Subdivision Comments

Date: 6/12/2023

RE: SP-23-00003 Hauglum Short Plat

HAUGLUM SHORT PLAT PART OF SECTION 34, T. 20 N., R. 15 E., W.M. KITITAS COUNTY, WASHINGTON

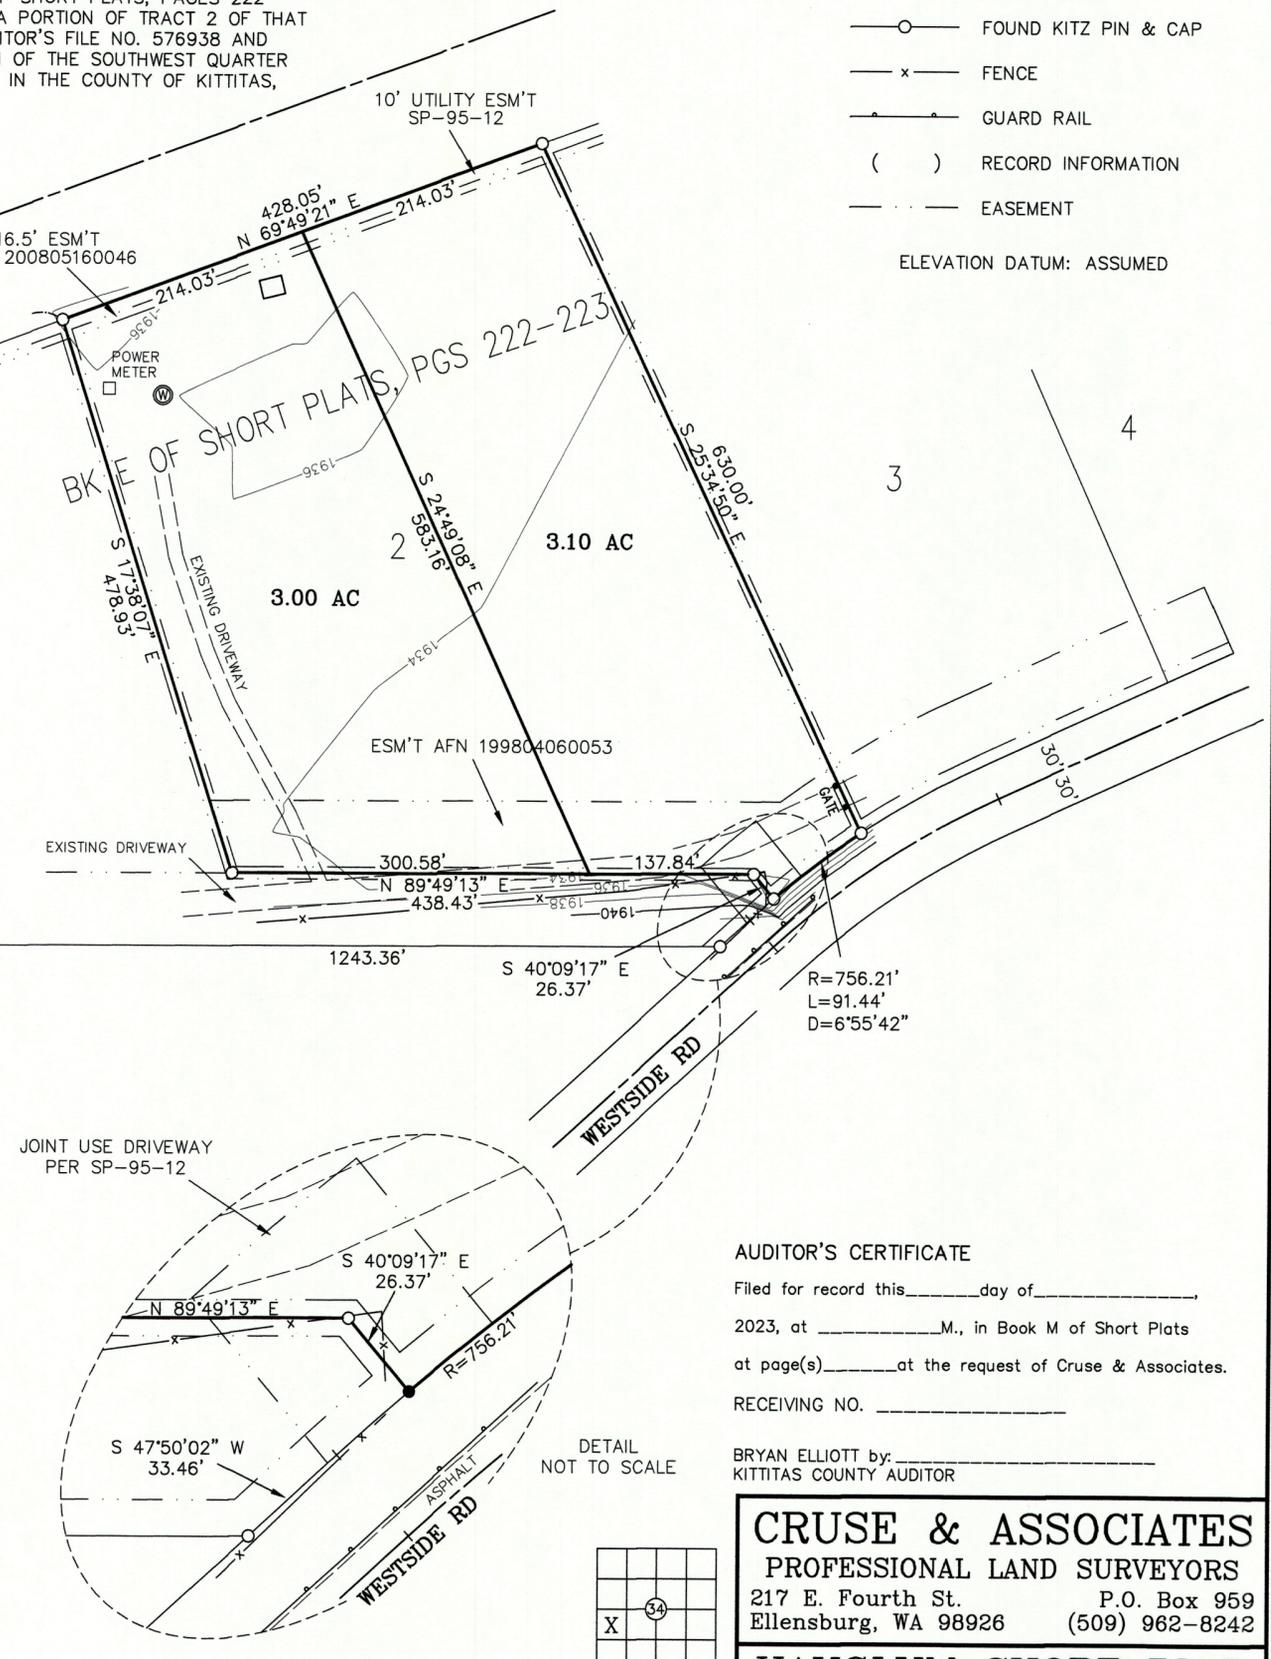
Any on-site septic systems that are to be utilized for wastewater management must adhere to the standards set by both the Washington Administrative Code, and Kittitas County Code. In accordance with KCC 13.04.090, a minimum of one soil log for each proposed lot where individual sewage disposal systems are contemplated must be completed. If community drain fields are to be utilized, soil logs must be done in the proposed locations of each. (See Conditions A-2).

Proposed short plat indicates individual and shared wells will be used. If the intention is to utilize a shared well, a signed, notarized, and filed shared well users agreement will also need to be provided before the short plat is finalized. If shared wells are to be utilized, the wells must be drilled a minimum of 50 feet from any proposed property line and a signed, notarized and recorded shared waters users' agreement for each shared well must be submitted to our office prior to final plat approval. The applicant must prove physical availability of water for all new uses of water proposed lots of this project, which can be provided by (See Condition A-1) a well log or 4 hour draw down test as proof of water availability for each new well proposed. All

A soil log is needed for the proposed lots

A signed and recorded shared water user's agreement between proposed lots is needed. Along with a current water right for the proposed lots.
